RE: CANDLELITA TOWNHOUSE

I have reviewed your request for an open channel in lieu of the pipe recommended in the drainage report for the subject property.

CANDELINA TOWN HOUSES

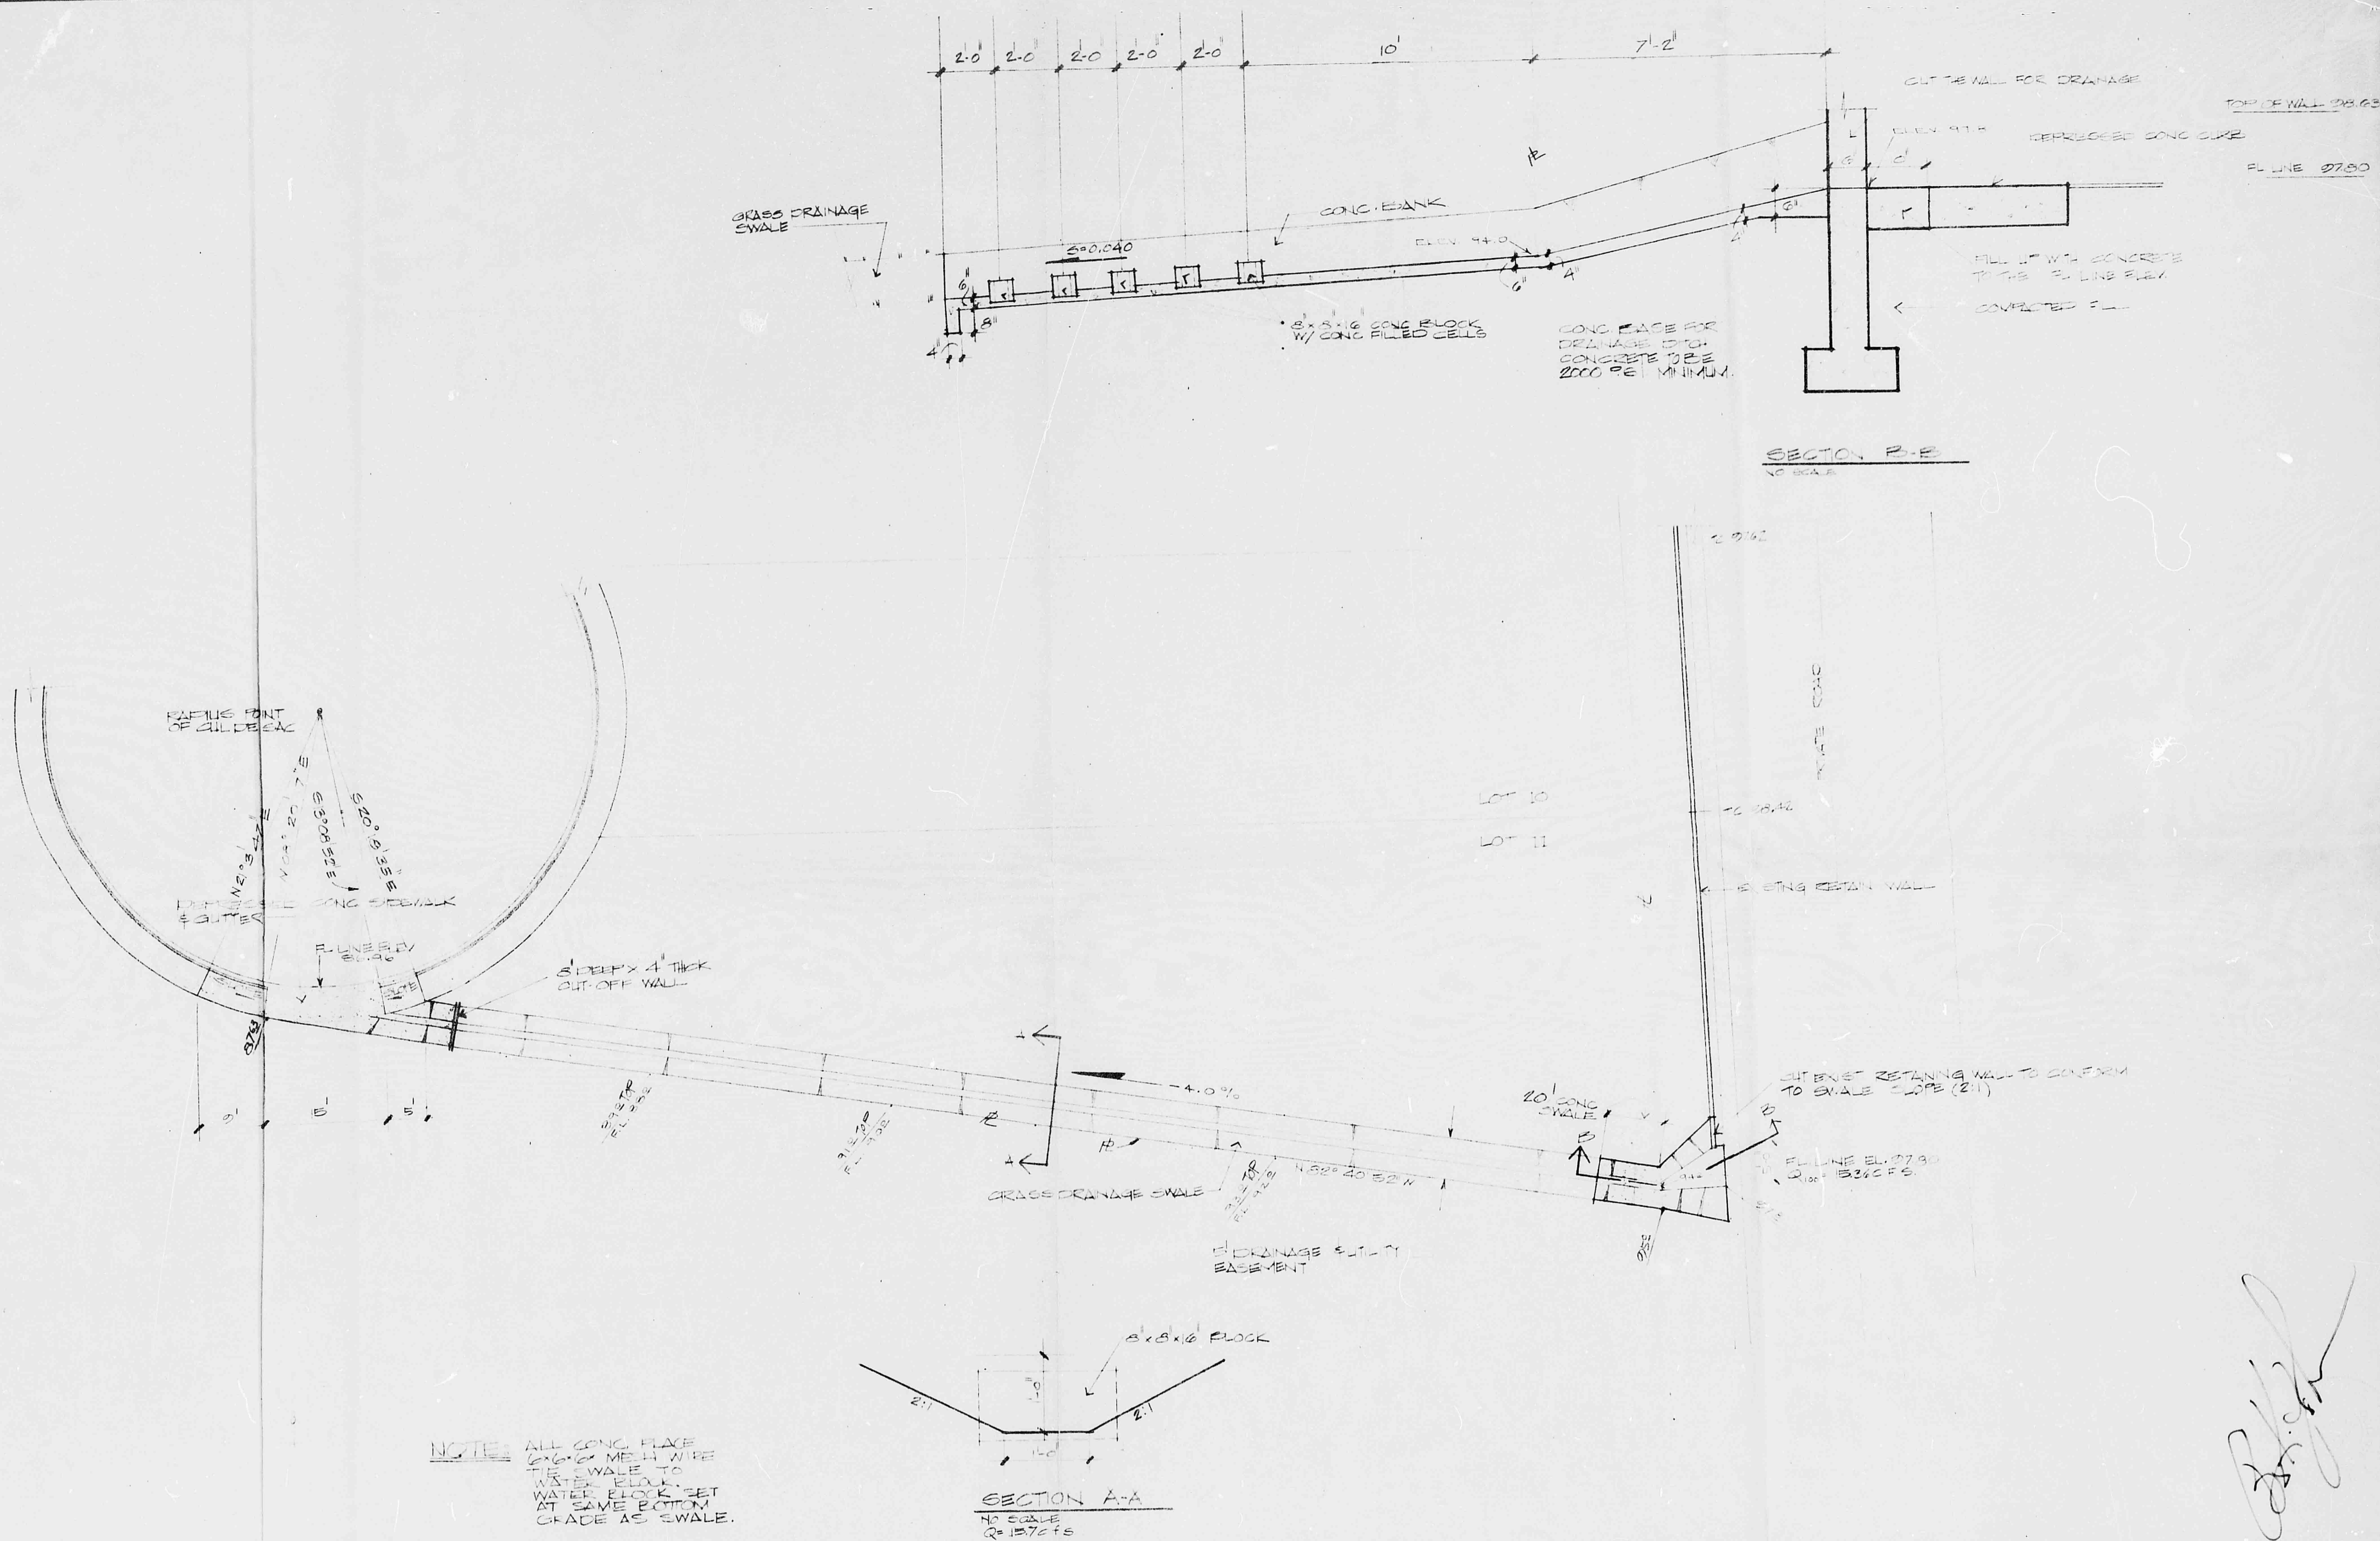
An open channel is an acceptable alternate. However, grass lined with 2:1 side slopes is unacceptable. Such steep slopes cannot be satisfactorily maintained.

I would also recommend the water be turned and directed north along the street to avoid possibility of flows climbing the water block. The pipe alternate satisfactorily provided that control of the water.
